KITTITAS COUNTY

MEMORANDUM

TO: All Staff
FROM: Public Works Plan Review Team
DATE: April 13, 2023
SUBJECT: BL-22-00028 Number 9 Ranch

PART OF THE NORTH HALF OF SECTION 9,
TOWNSHIP 18 NORTH, RANGE 18 EAST, W.M.

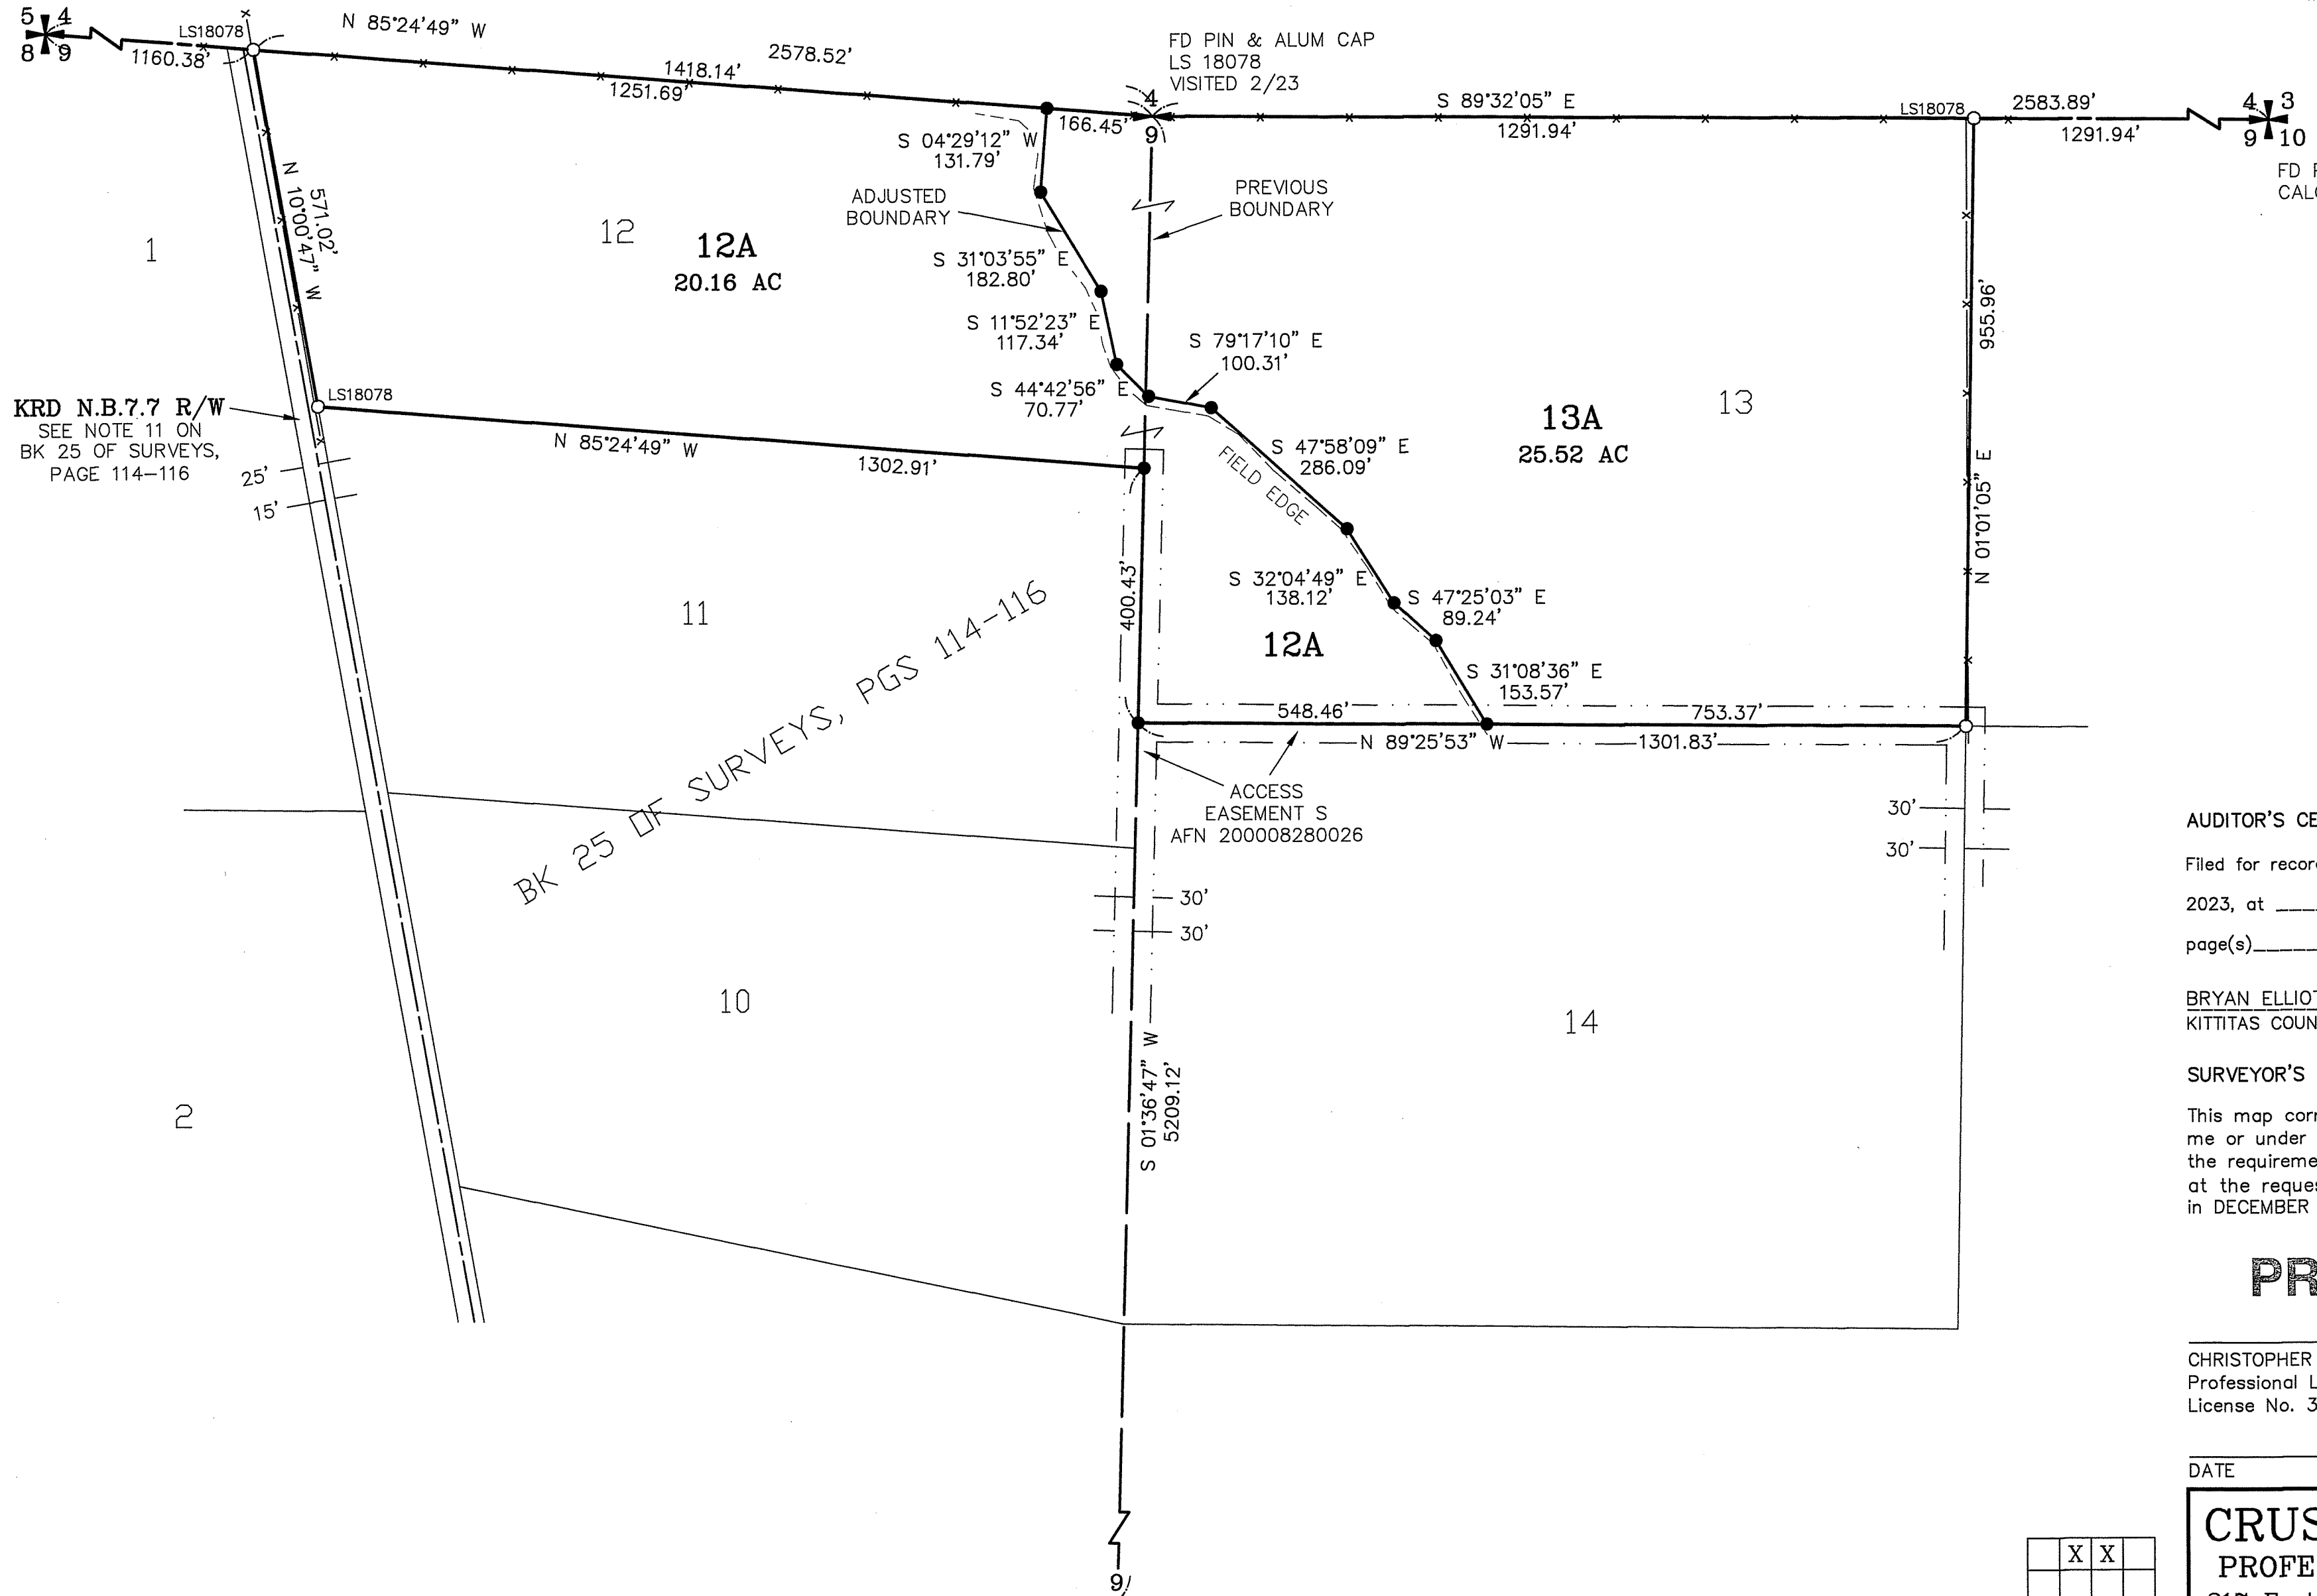
ACCESS	<ol style="list-style-type: none">1. An approved access permit shall be required from the Kittitas County Department of Public Works prior to creating any new driveway access or altering an existing access.2. Maintenance of driveway approaches shall be the responsibility of the owner whose property they serve. The County will not maintain accesses.3. Any further subdivision or lots to be served by proposed access may result in further access requirements. See Kittitas County Road Standards.4. In addition to the above-mentioned conditions, all applicable Kittitas County Road Standards apply to this proposal. Access is not guaranteed to any existing or created parcel on this application.
ENGINEERING	No comments (KH)
SURVEY	As no survey map was provided in the application, comments are reserved until final. (JT) PRELIM FINAL REVIEW <ol style="list-style-type: none">1. Please clarify if the NE corner of Sec 9 is found or calculated.
